**Albuquerque
Metropolitan
Arroyo
Flood
Control
Authority**

December 22, 2005

Re: AMAFCA Does Not Accept the Drainage Improvements for Maintenance
Quivera Estates Subdivision

QUIVERA ESTATES
SEDIMENTATION POND REPAIR

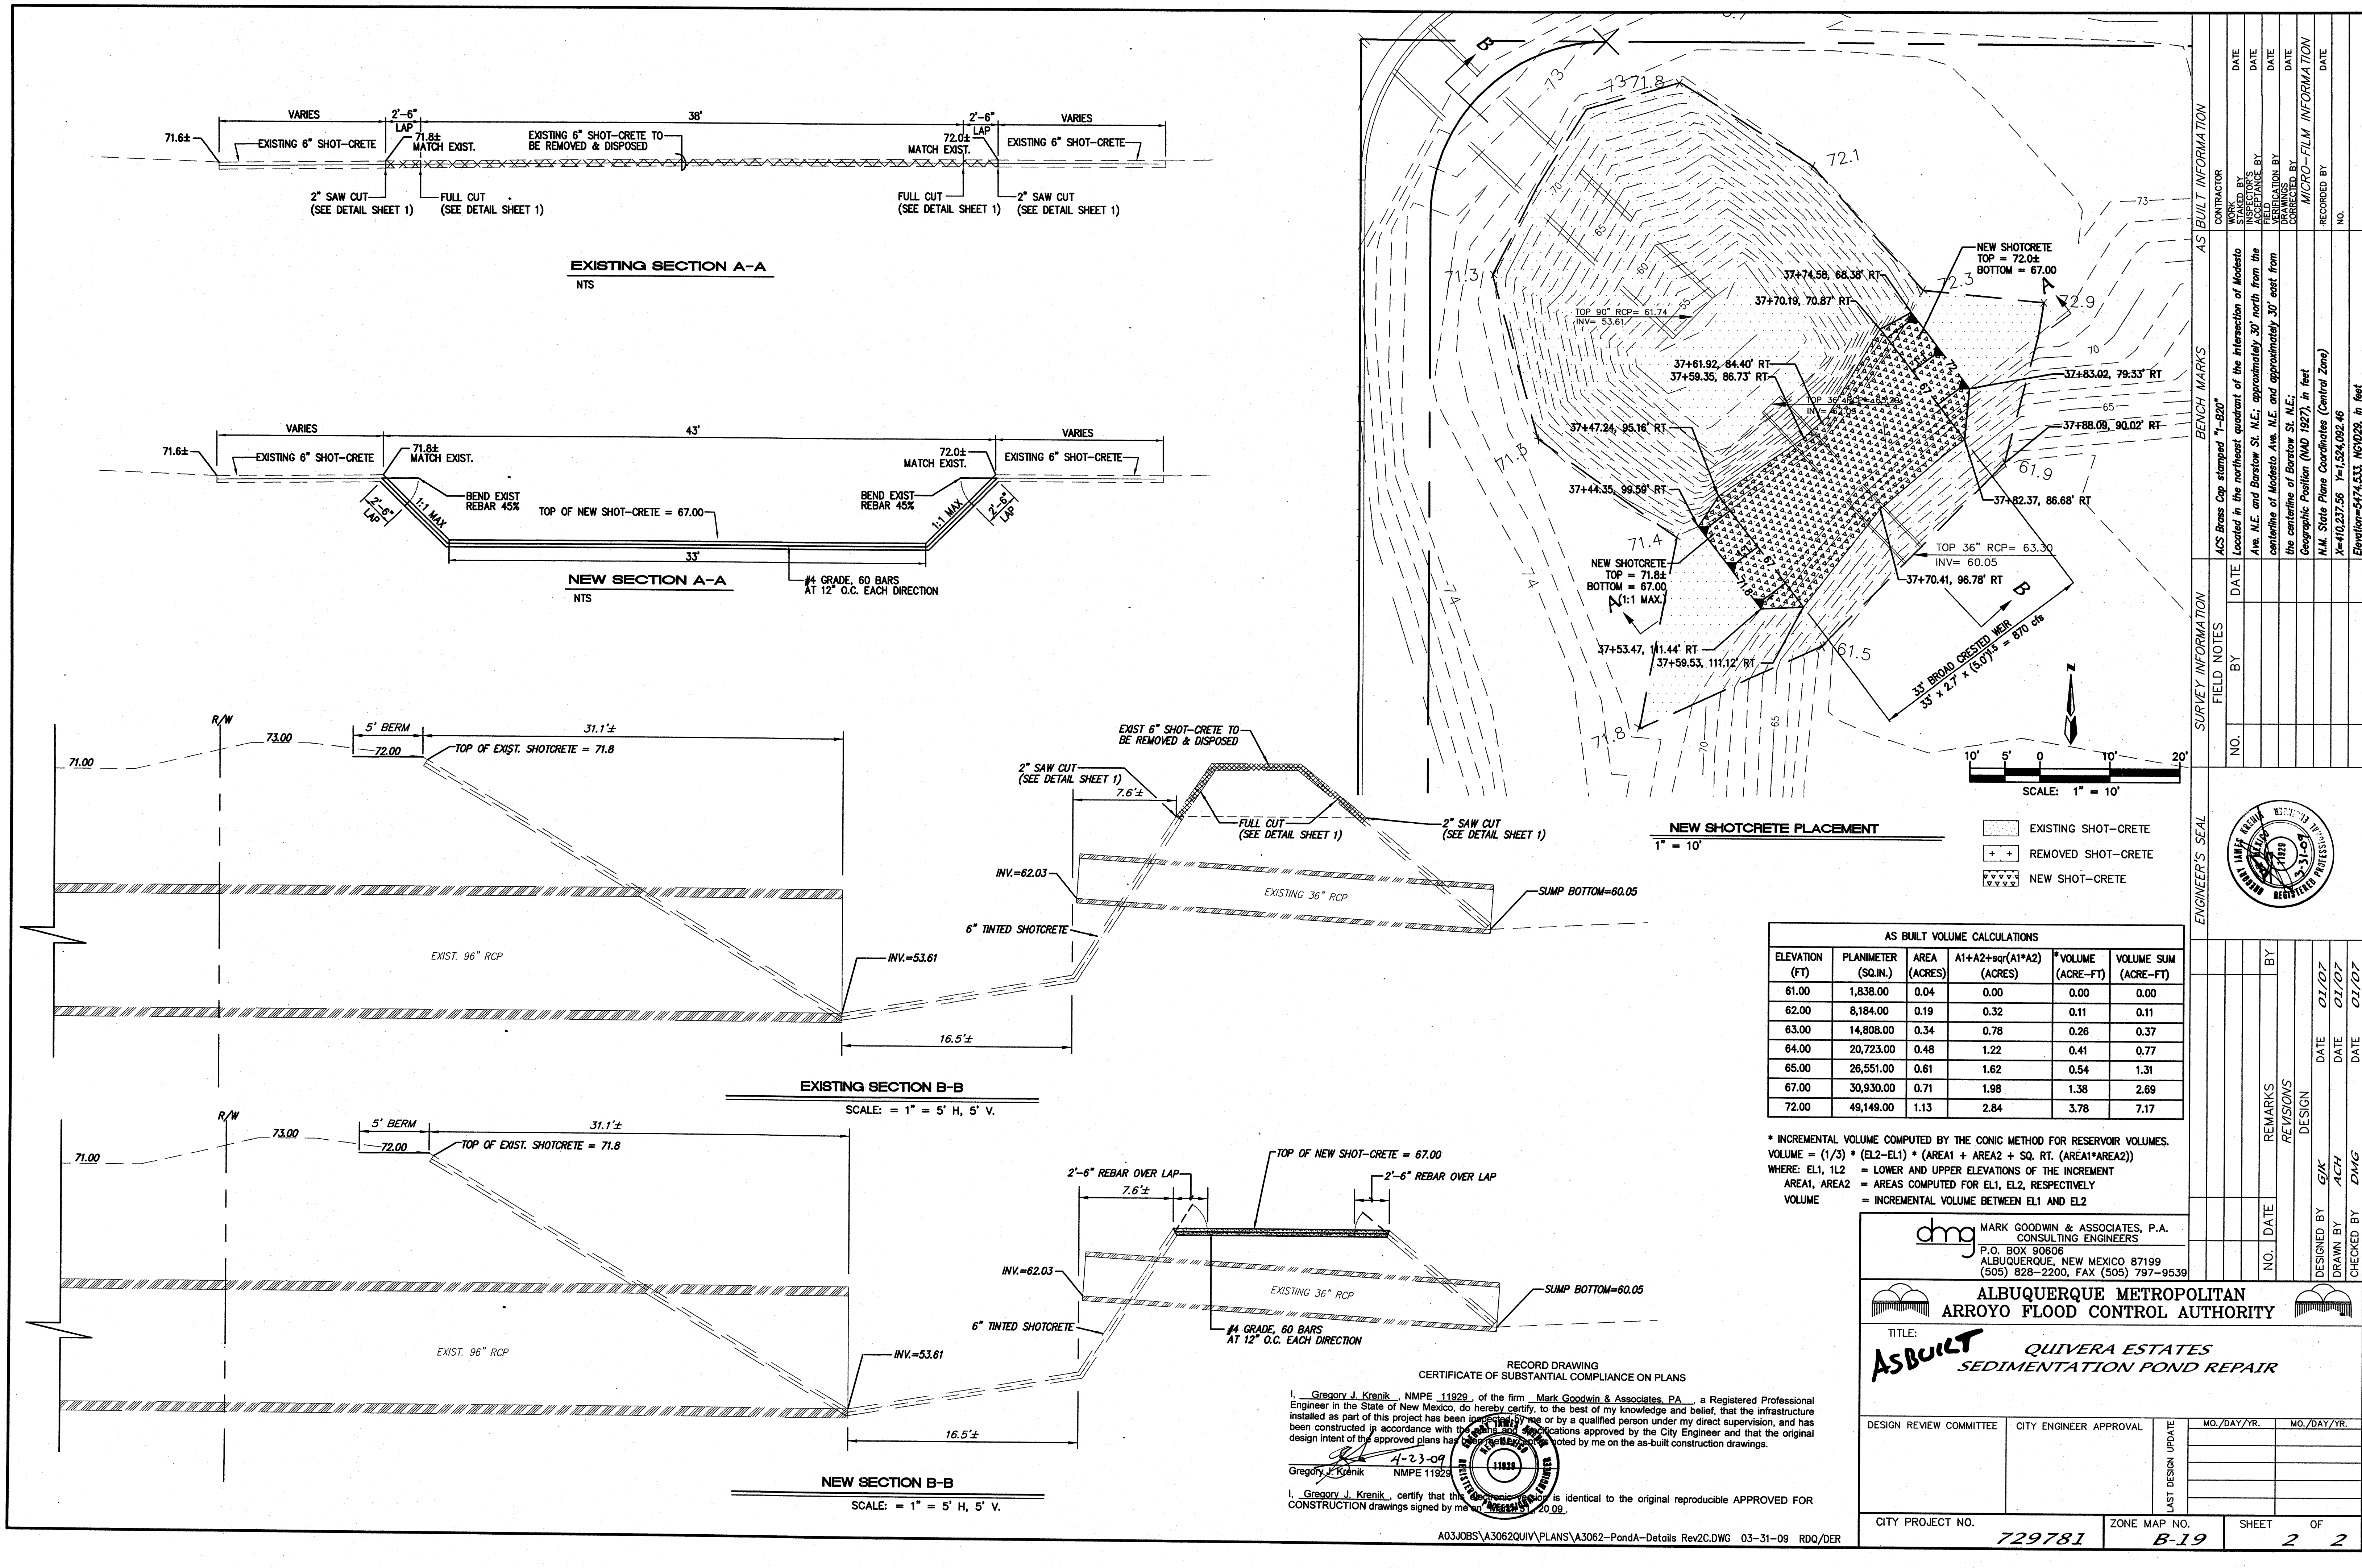
The pond shown on the approved plans was not constructed to the lines and grades shown. Consequently, AMAFCA did not accept the drainage improvements after construction and instructed Leo Valdez, Construction Observer, for Mark Goodwin & Associates, that AMAFCA would require that the pond be constructed to the lines and grades shown on the plans. I contacted Mr. Greg Krenik, P.E., the design engineer for the project concerning the construction deficiencies that were found.

Remedial work was done on the pond in an attempt to address the construction deficiencies. Additional fill has been placed on the pond berm, but the fill was not benched or tied into the existing berm nor was the fill moisture conditioned and compacted. The modification to the pond is not acceptable.

Please submit to AMAFCA a remediation plan to address elevation deficiencies for all embankments associated with the diversion berm and pond located at Glendale and Barstow. All work shall meet the lines and grades shown on your plans for City of Albuquerque Project No. 729781 and shall be supported by appropriate geotechnical testing. All work will need to be completed by February 1, 2005. The remediation plan shall be submitted to AMAFCA no later than close of business January 5, 2006.
